**Response to Comments on the Draft Response to Submissions – Edge Estate (SSD-17552047)
141-251 Aldington Road, Kemps Creek**

We write on behalf of FPI Developments NSW Pty Ltd ('Frasers Property Industrial' or 'the Applicant') in response to the Department of Planning, Housing and Infrastructure's (DPHI's) comments on the draft Response to Submissions issued via email on 24 May 2024.

Table 1 Response to Comments on Draft Response to Submissions

Status	<b>SSD APPROVAL</b> <b>NOT FOR CONSTRUCTION</b>	A1
Project - Drawing No.	20-776-C1201	Issue
		C

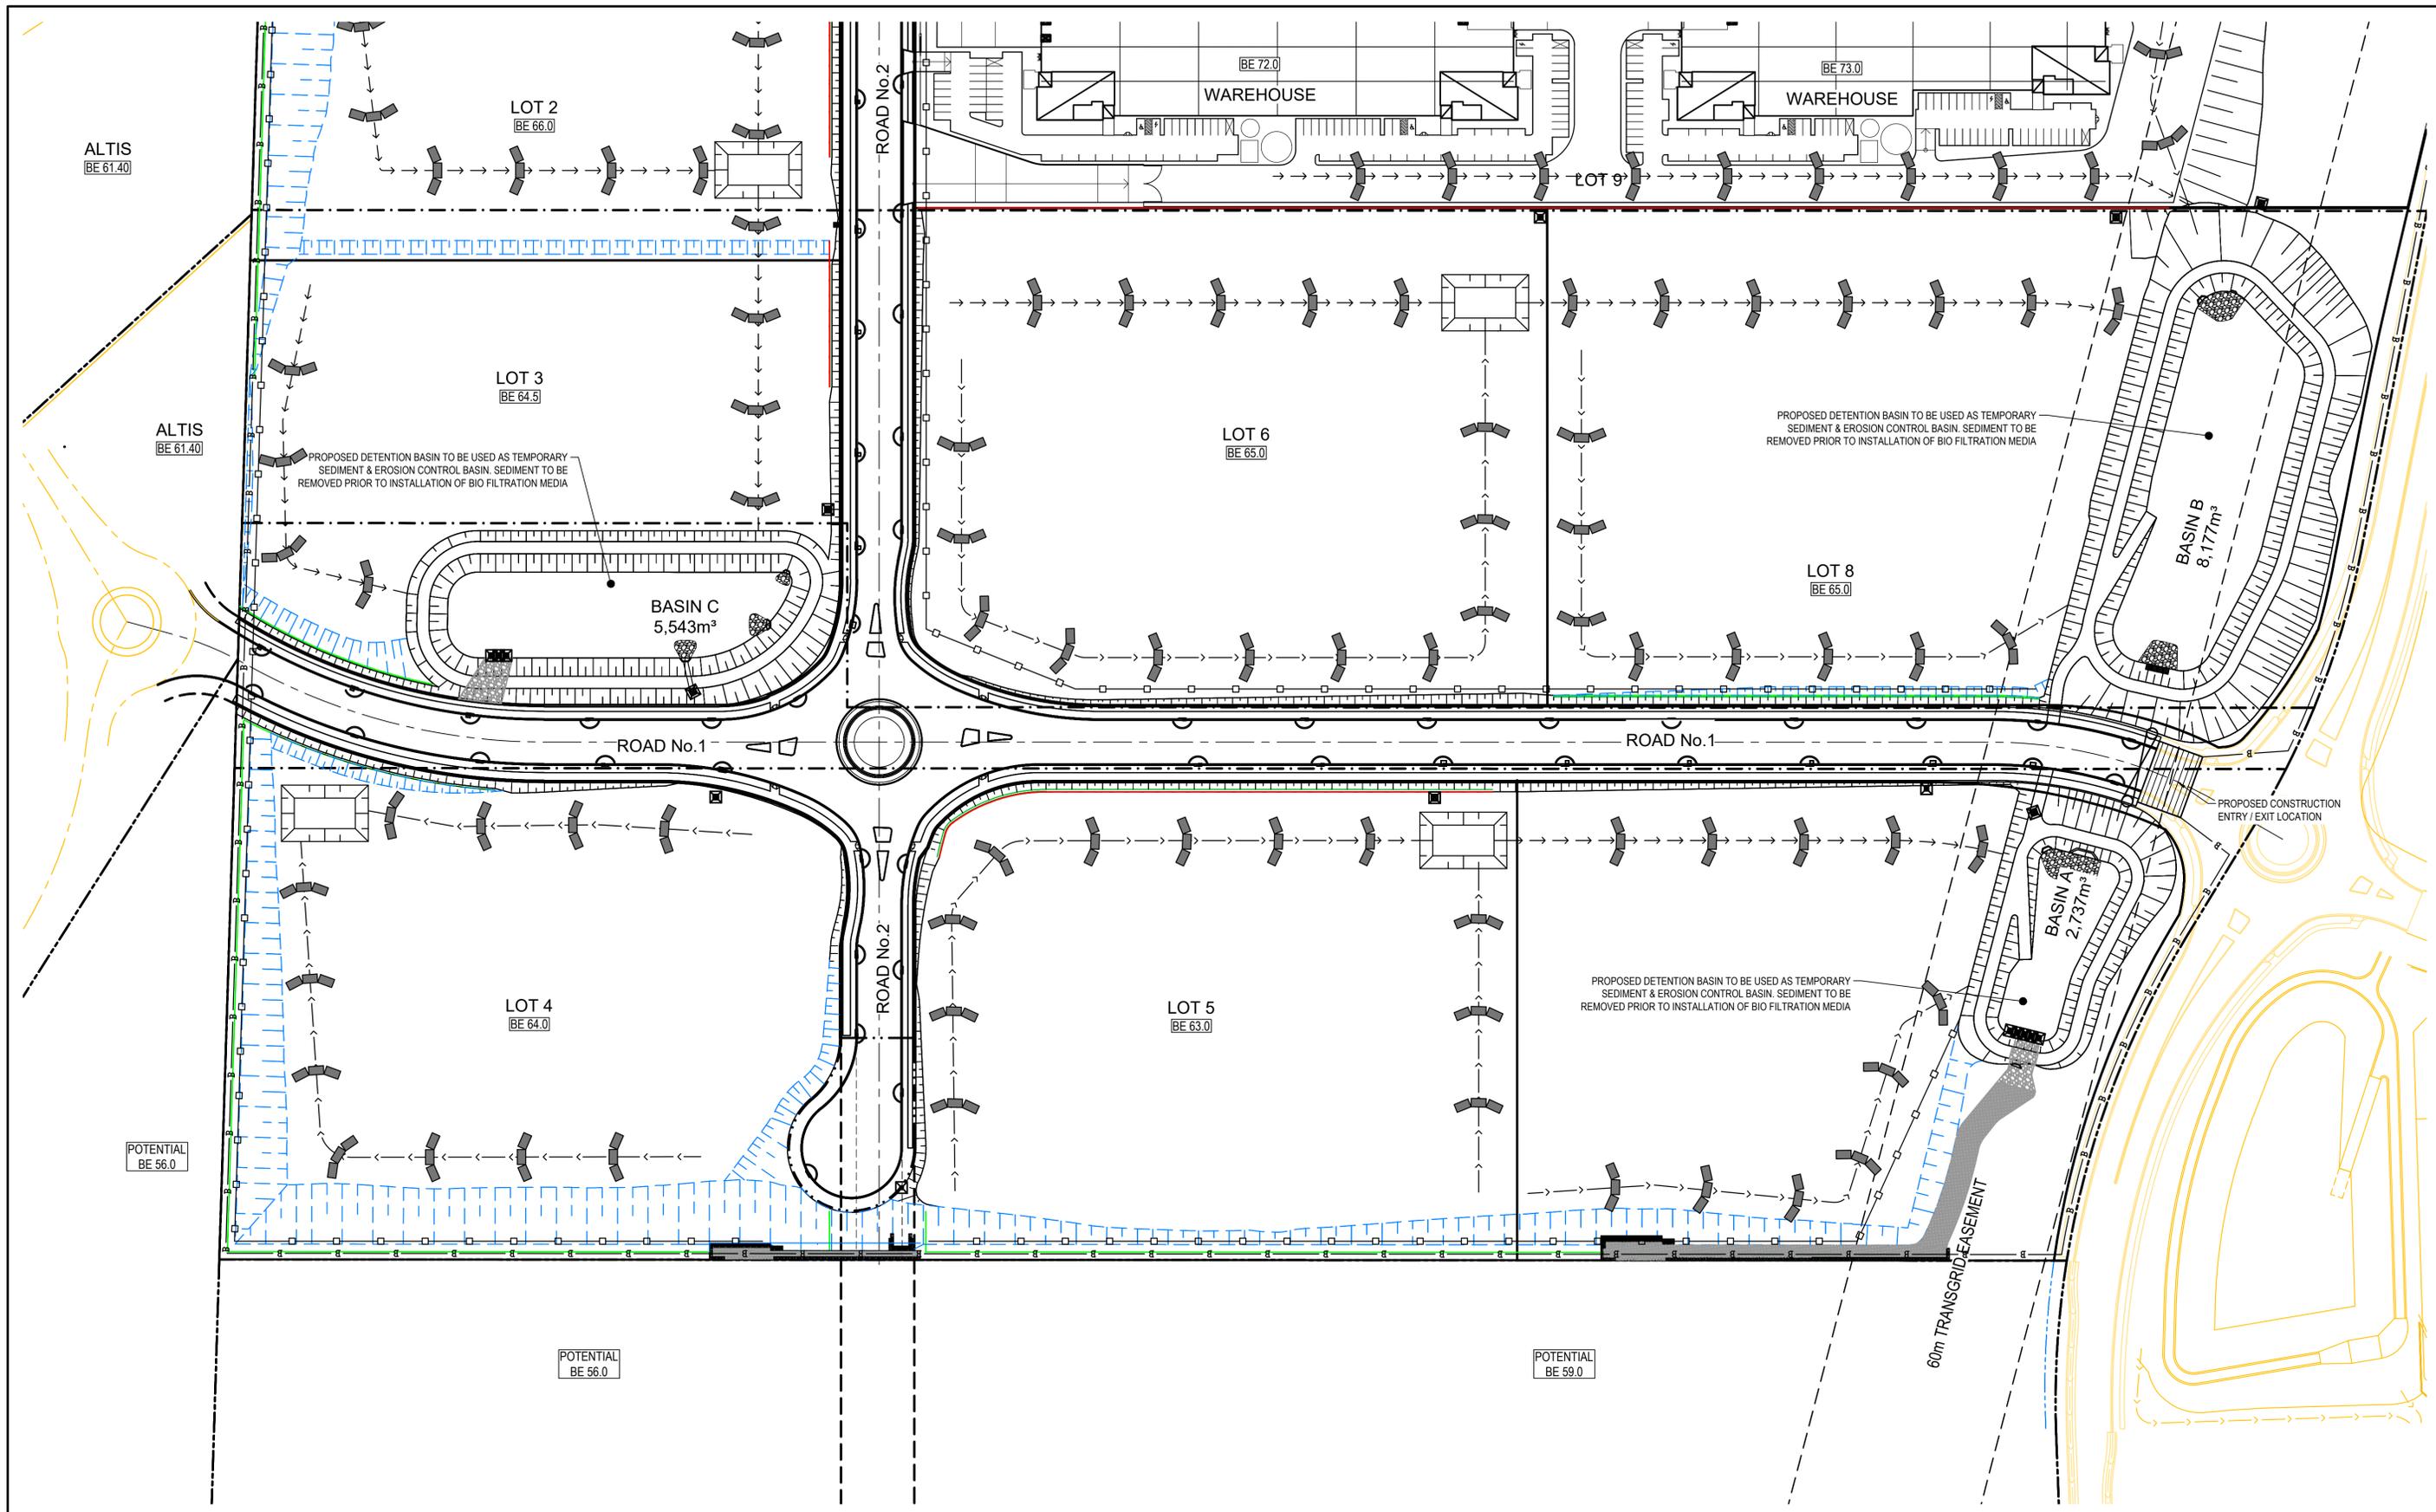
7. The ESCP drawings (20-776-C1201, 1202 and 1203) indicate that some lots will utilise the OSD basins as sediment basins. Clarify how erosion and sediment control measures will be implemented for undeveloped lots (including Lots 12-14) once the basins and trunk drainage are operational.

As outlined in the Civil TOA Response (**Attachment B**), the updated Civil Drawings (**Appendix E** of the Submissions Report) and updated Erosion and Sediment Control Plan (**Appendix H** of the Submissions Report) clarify the requirements for sediment basins on undeveloped lots (9-14) once OSD basins and trunk drainage are in their final operational form. The undeveloped lots will require either full stabilisation or implementation of a

sediment basin to mitigate potential impacts of erosion and sedimentation. We have provided a much clearer set of erosion and sediment control plans which provide further clarity of the design.
